From: Thomas Callaway
Sent: 04 June 2015 11:22
To: Planning.Responses
Subject: RE: Planning Consultation on: AL/42/15/HH

APPLICATION **AL/42/15/HH**

Site Address: 9 Elmcroft Place Aldingbourne PO20 3XL

Description of Works: Two storey side extension to replace garage & single storey rear extension.

Proposed Roof Plan
1 : 100

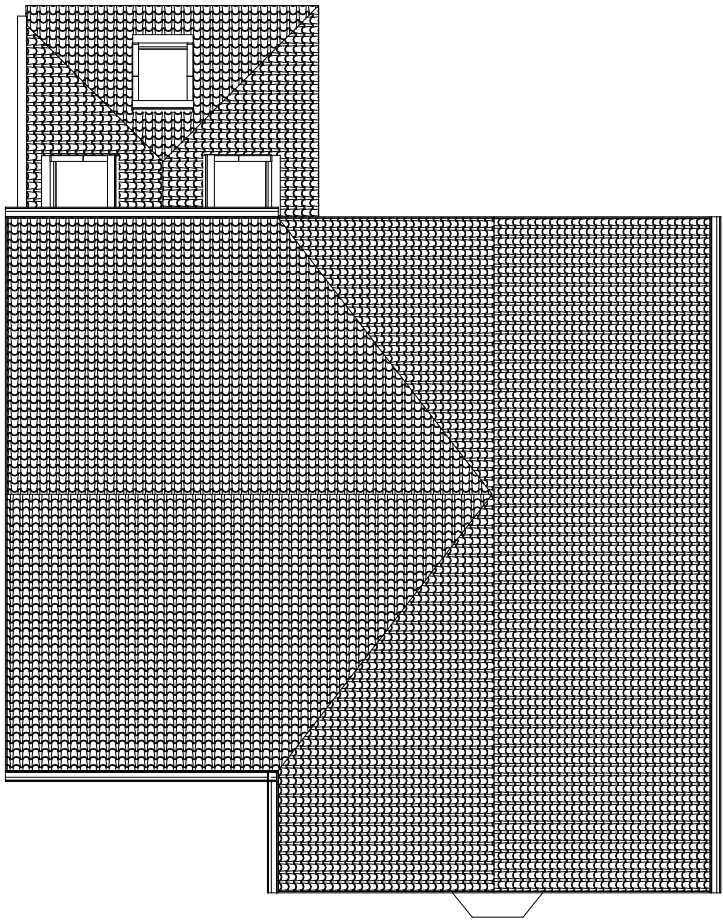
Soakage should be investigated for new roof area.

Please apply standard conditions ENGD2A.

Infiltration rates for soakage structures are to be based on percolation tests undertaken in the winter period and at the location and depth of the proposed structures. The percolation tests must be carried out in accordance with BRE 365, CIRIA R156 or a similar approved method and cater for the 1 in 10 year storm between the invert of the entry pipe to the soakaway, and the base of the structure. It must also have provision to ensure that there is capacity in the system to contain below ground level the 1 in 100 year event plus 30% on stored volumes, as an allowance for climate change. Adequate freeboard must be provided between the base of the soakaway structure and the highest recorded annual groundwater level identified in that location.

Any SuDS or soakaway design must include adequate groundwater monitoring data to determine the highest winter groundwater table in support of the design. The applicant is advised to discuss the extent of groundwater monitoring with the Council's Engineers. Supplementary guidance notes are also enclosed for information.
